16. APPENDIX J - SCHEDULE OF DRAINAGE PLAN REVISIONS

SCHEDULE OF MINOR CHANGES TO APPROVED SURFACE WATER DRAINAGE DRAWINGS

DETAIL AG: ACCESS GULLY  
SCALE 1:10

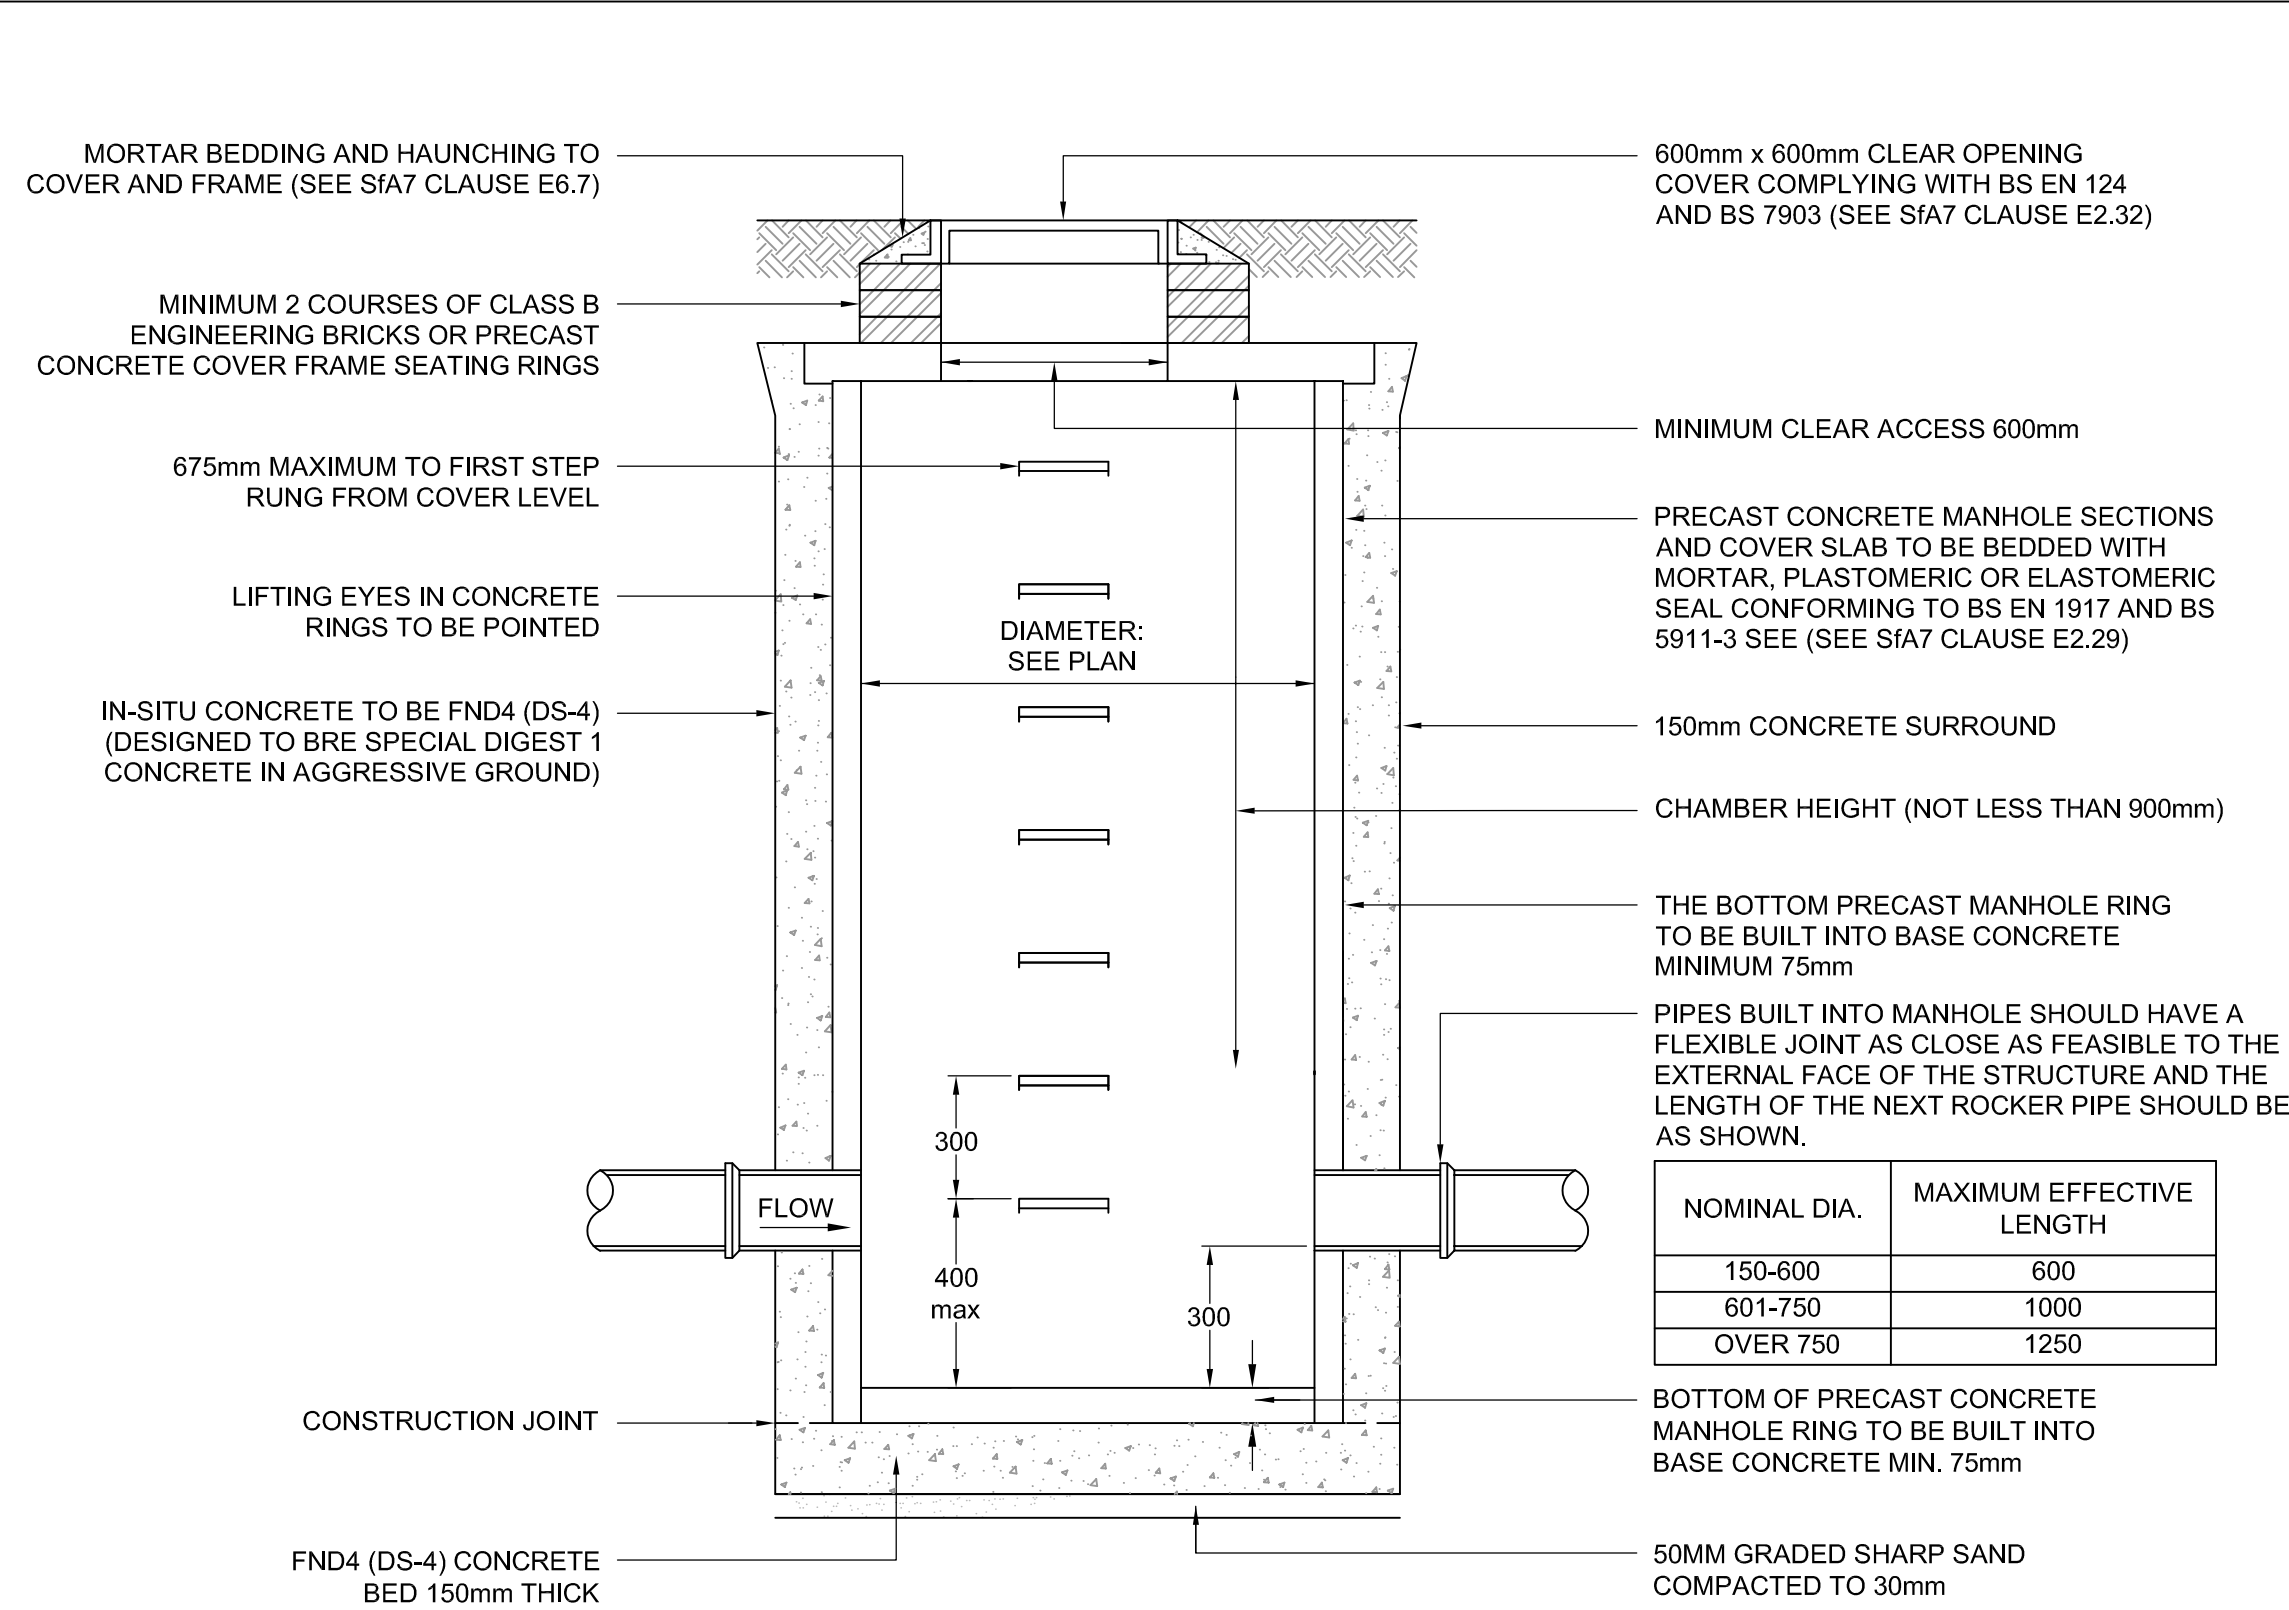
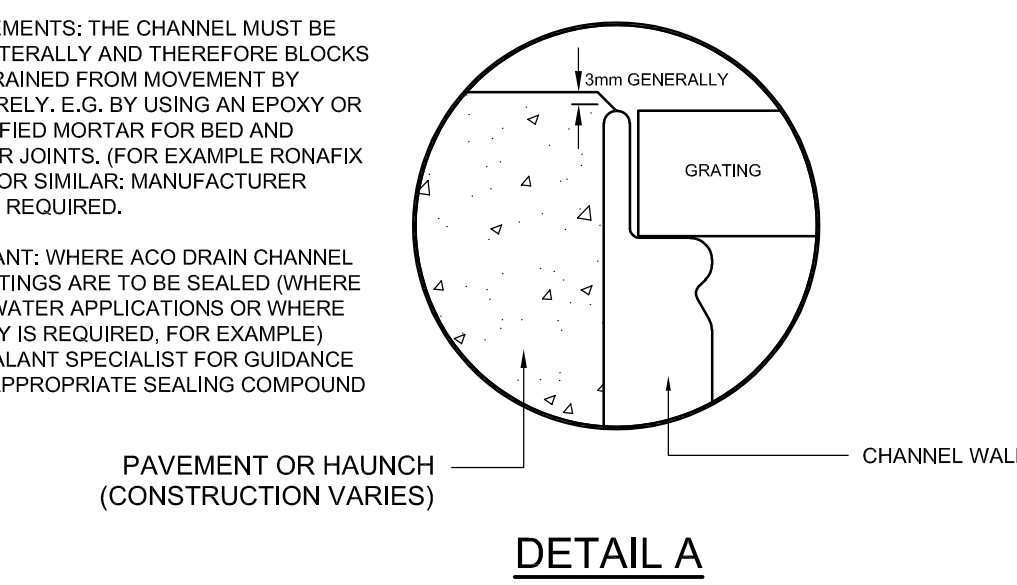
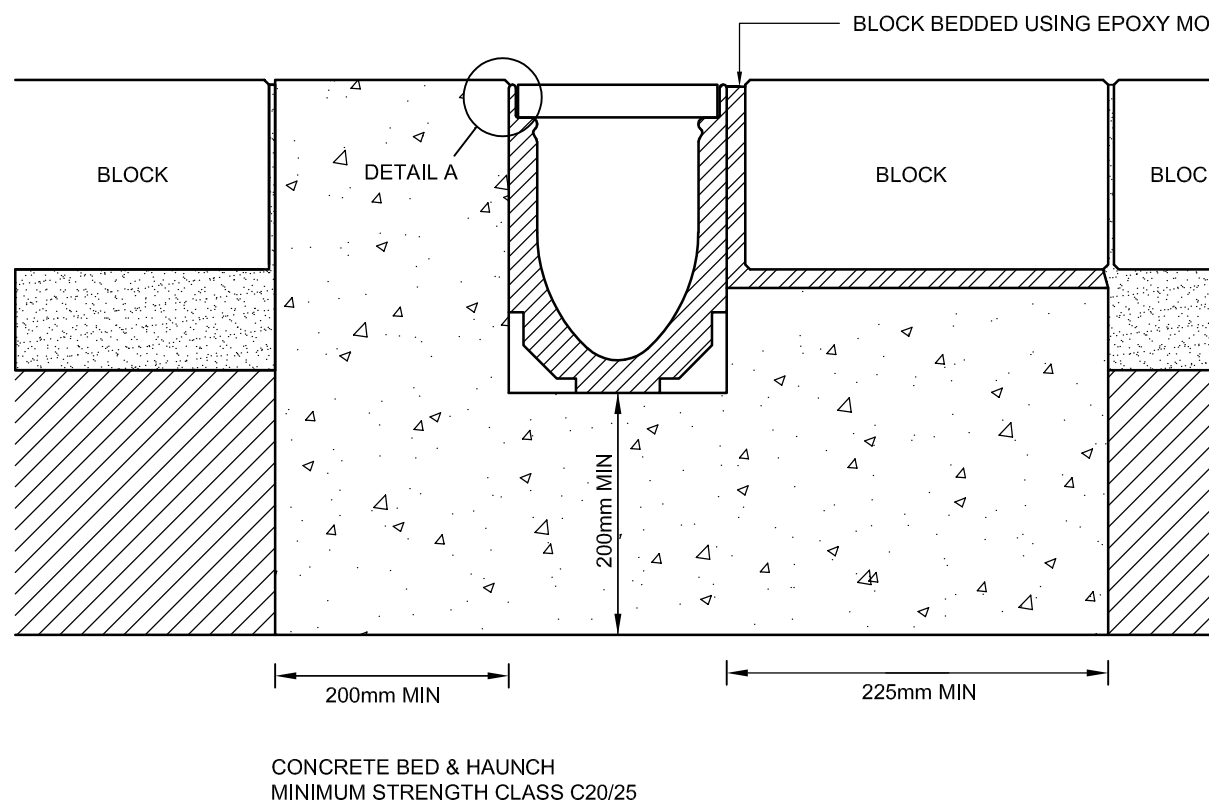
SAL-HYD-PH1-ZZ-DR-C-7102			
Rev P05	ARUN Approved Issue.		
Rev C01	Construction Issue *no changes*		
Rev C02	As built Issue *no changes*		
Rev C03	H&S Issue - title block changed	title block changed	Error corrected
Rev C04	As built Issue - title block changed	title block changed	Changed back to As-built
SAL-HYD-PH1-ZZ-DR-C-7103			
Rev P09	ARUN Approved Issue.		
Rev C01	Construction Issue *no changes*		
Rev C02	H&S Issue - title block changed	title block changed	Error corrected
Rev C03	As built Issue - title block changed	title block changed	Changed back to As-built
SAL-HYD-PH1-ZZ-DR-C-7104			
Rev P10	ARUN Approved Issue.		
Rev C01	Construction Issue *no changes*		
Rev C02	Note added. GW and manhole sump added	Note added. GW and sump added	Additional information. Sump required in MH's
Rev C03	H&S Issue - title block changed	title block changed	Error corrected
Rev C04	As built Issue - title block changed	title block changed	Changed back to As-built
